# CITY OF ALBUQUERQUE

August 4, 2022

**RE: 12100 Copper  
Grading and Drainage Plan  
Engineer's Stamp Date: 6/15/2022  
Hydrology File: K22D064**

Based upon the information provided in your submittal received 6/15/2022, the Grading & Drainage Plan is **not** approved for Grading or Building Permit. The following comments need to be addressed for approval of the above referenced project:

ENGINEER'S SEAL	12100 COPPER TOWNHOMES	DRAWN BY WCVJ
	GRADING AND DRAINAGE PLAN	DATE 6-14-22
		20220047-LAYOUT-6-14-22
		SHEET # -
11/18/22	 <i>Rio Grande Engineering</i> 1606 CENTRAL AVENUE SUITE 201 ALBUQUERQUE, NM 87106 (505) 872-0399	JOB # 20220047
DAVID SOULE P.E. #14522

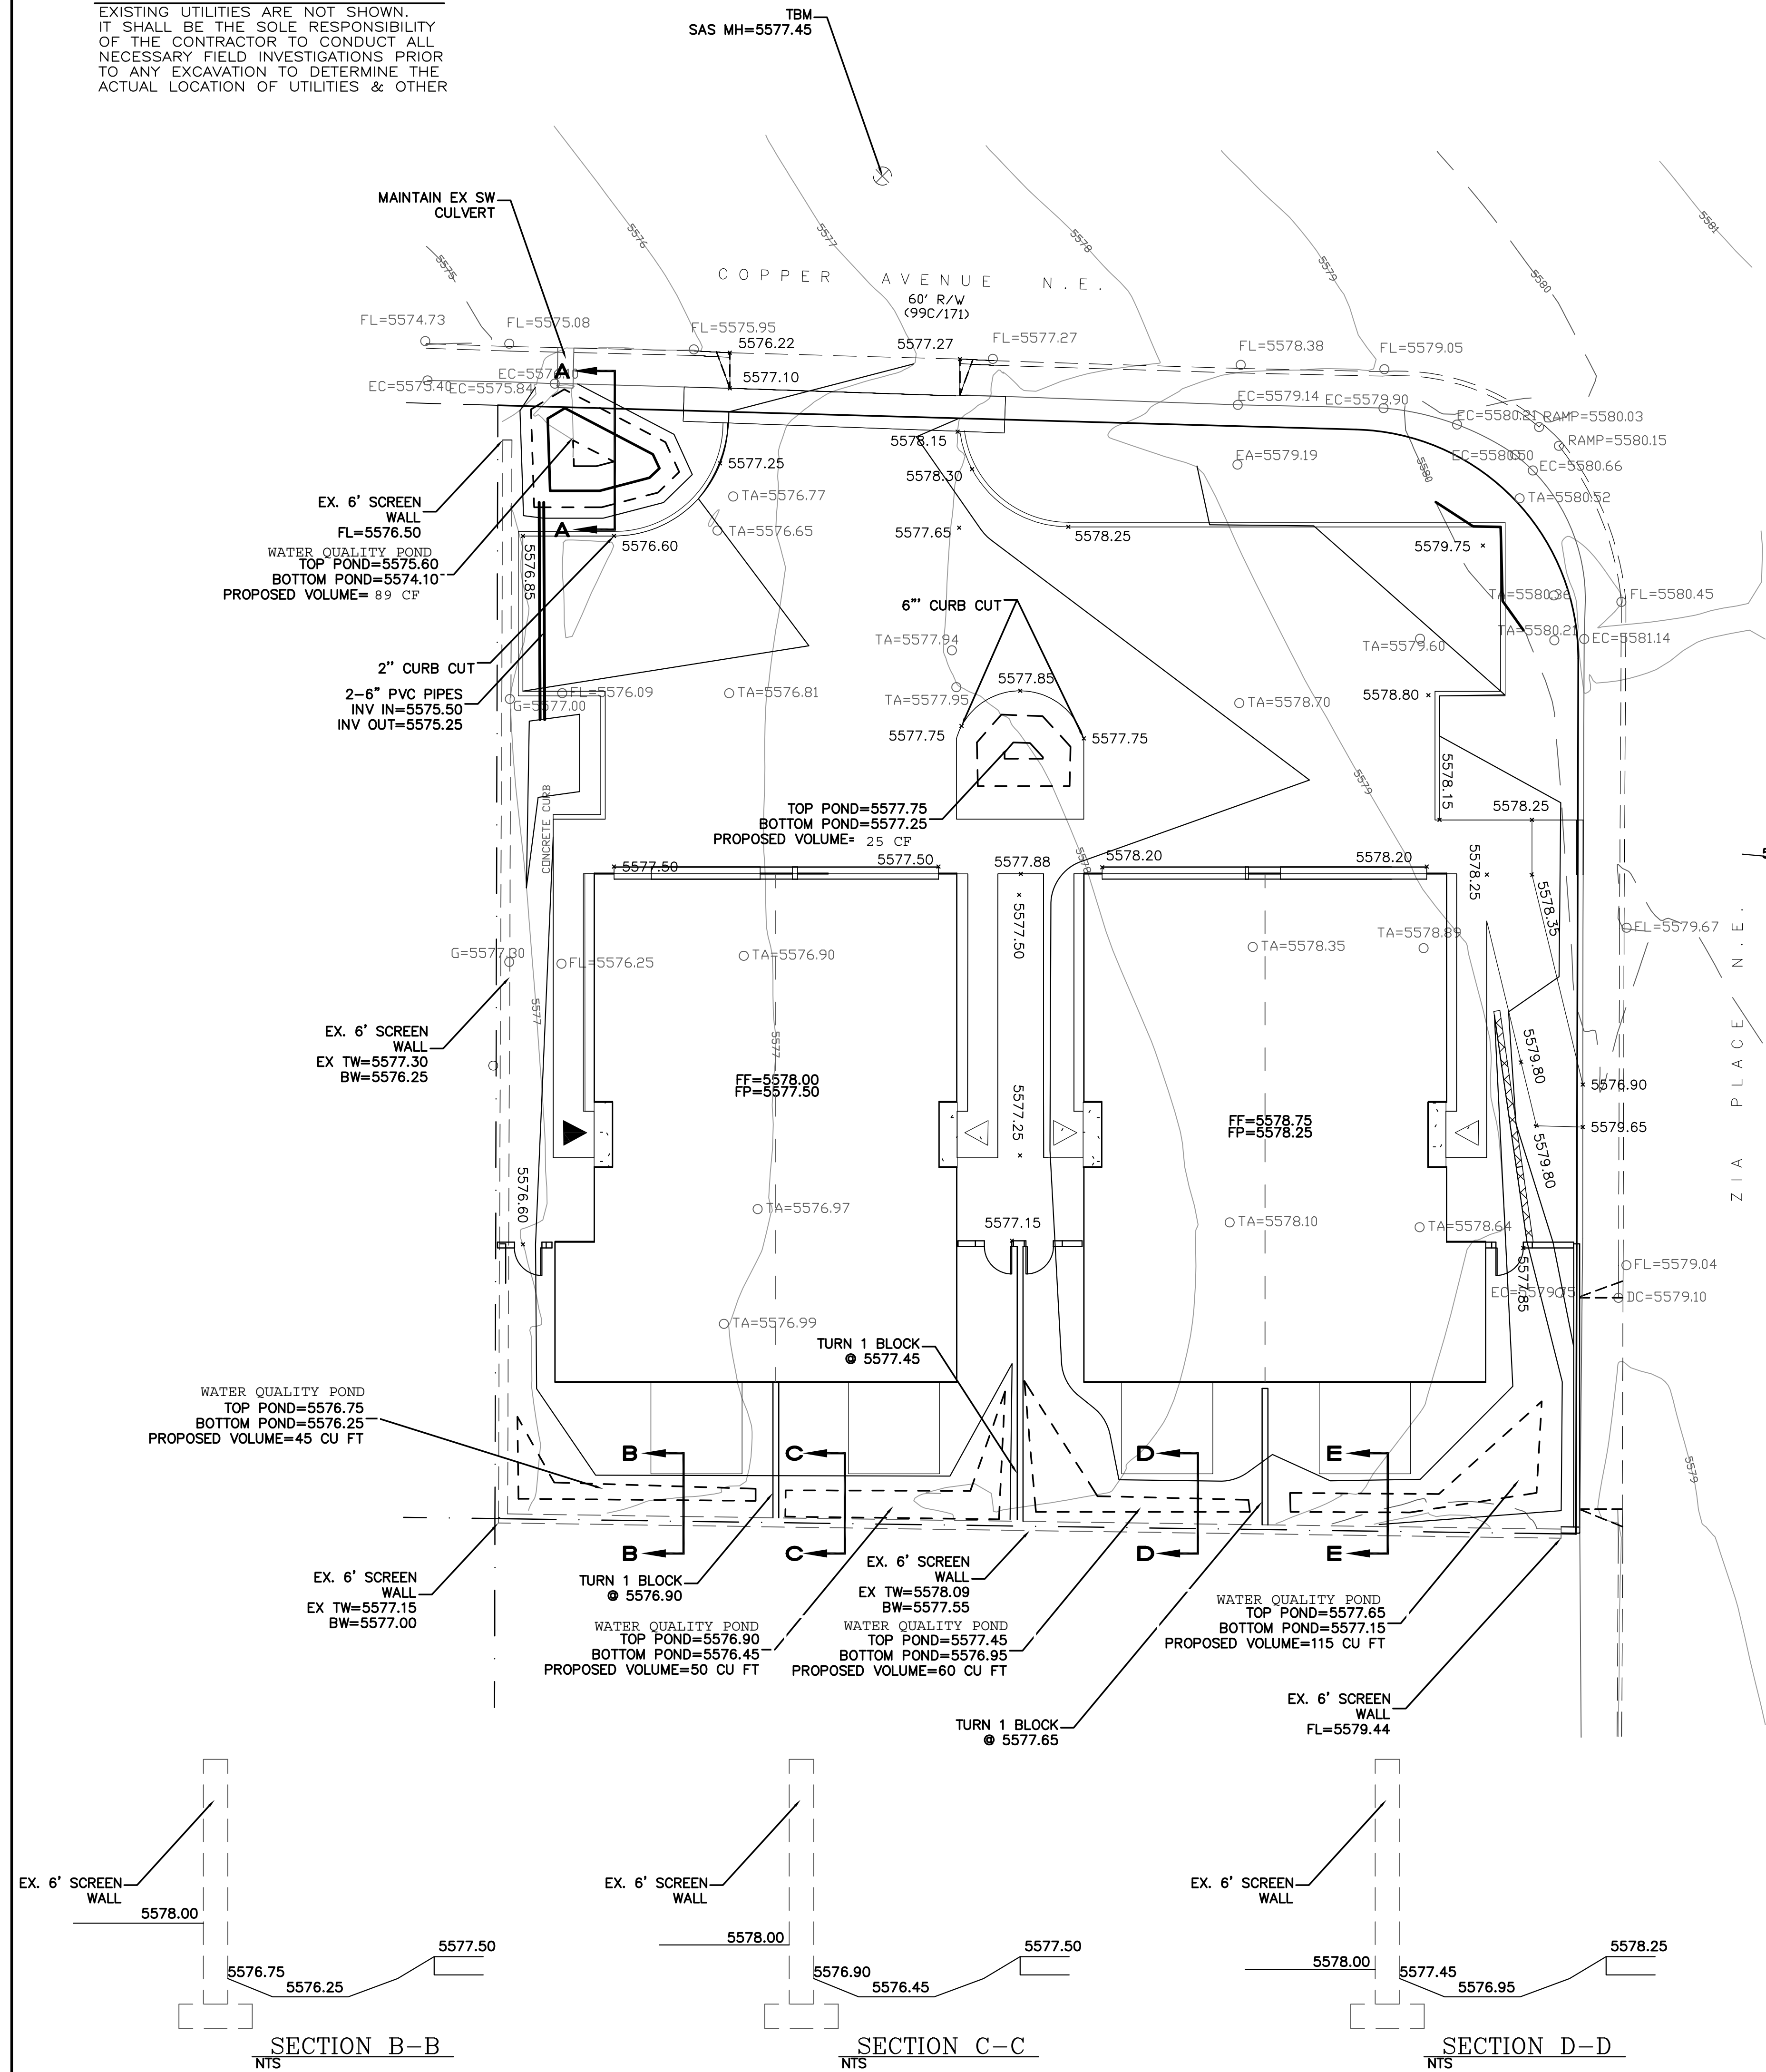
1. Please provide pond sections with elevations for:
  - a. Bottom, top, outlet, and SWQV. Back pond/front pond.
  - b. Are these stormwater quality ponds? Detention?
  - c. Please label ponds.
2. Please make the small text large enough to read at scale.
3. Please include benchmark and datum.
4. Is there an existing wall? If so call it out with BW/TW elevations.
- 5.
